Pre Development Enquiry

Site Address: Comet Hotel, St Albans Road West, Hatfield, AL10 9RH

Development Details: Existing site serving as hotel impermeable: 9400sqm with 128 bedrooms existing sw rates 1 in 1: 23l/s 1 in 10: 45.2l/s 1 in 30: 75.6l/s 1 in 100: 75.3l/s discharging via combined connection into MH1301 and MH2301. Development proposal for 308 bed hotel and 56 holiday apartments, impermeable 7200 sqm. Foul discharge by gravity into existing connections, SW proposal to pump at 5l/s for all storm events into unmapped SW chamber as shown on drawing FW1263 - 400C4

FW1263 400C13

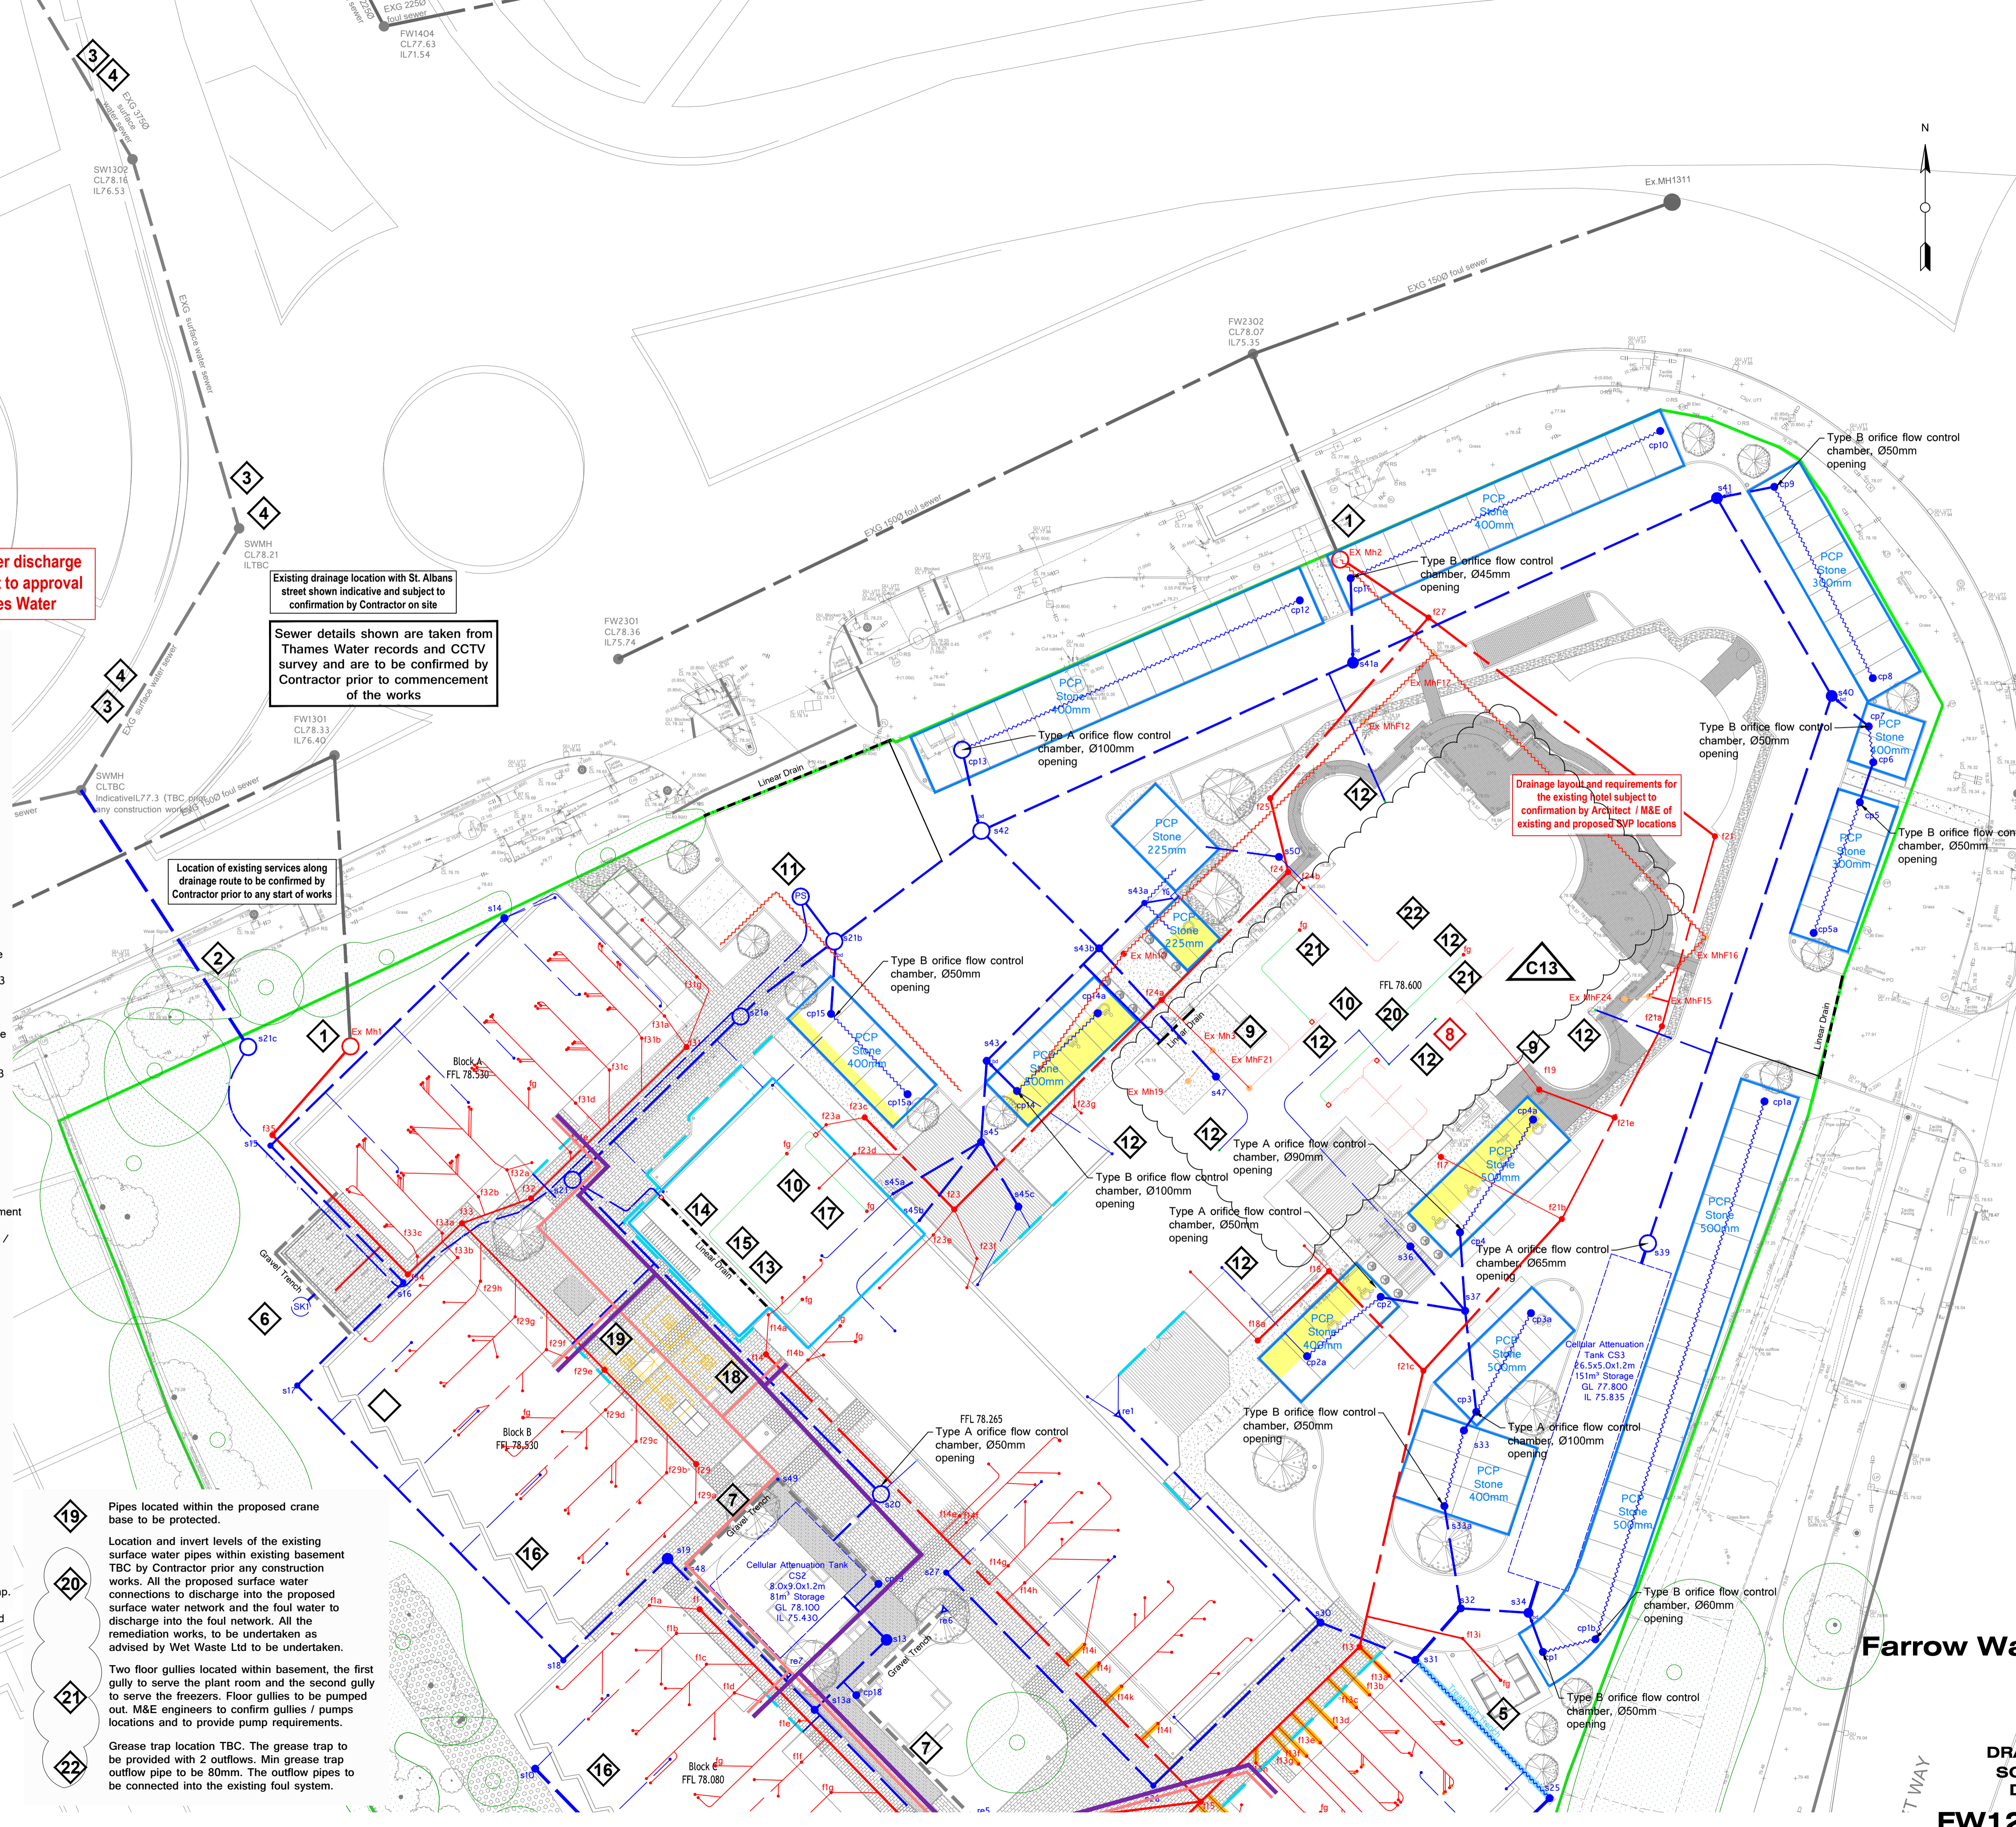
Thames Water recognises that the proposal for surface water discharge of 5l/s into the existing highway drain. We can confirm that the 1200mm surface water sewer system has sufficient capacity for the proposed flow subject to the highway drain being offered for adoption and subject to the completion of a Vesting Certificate.
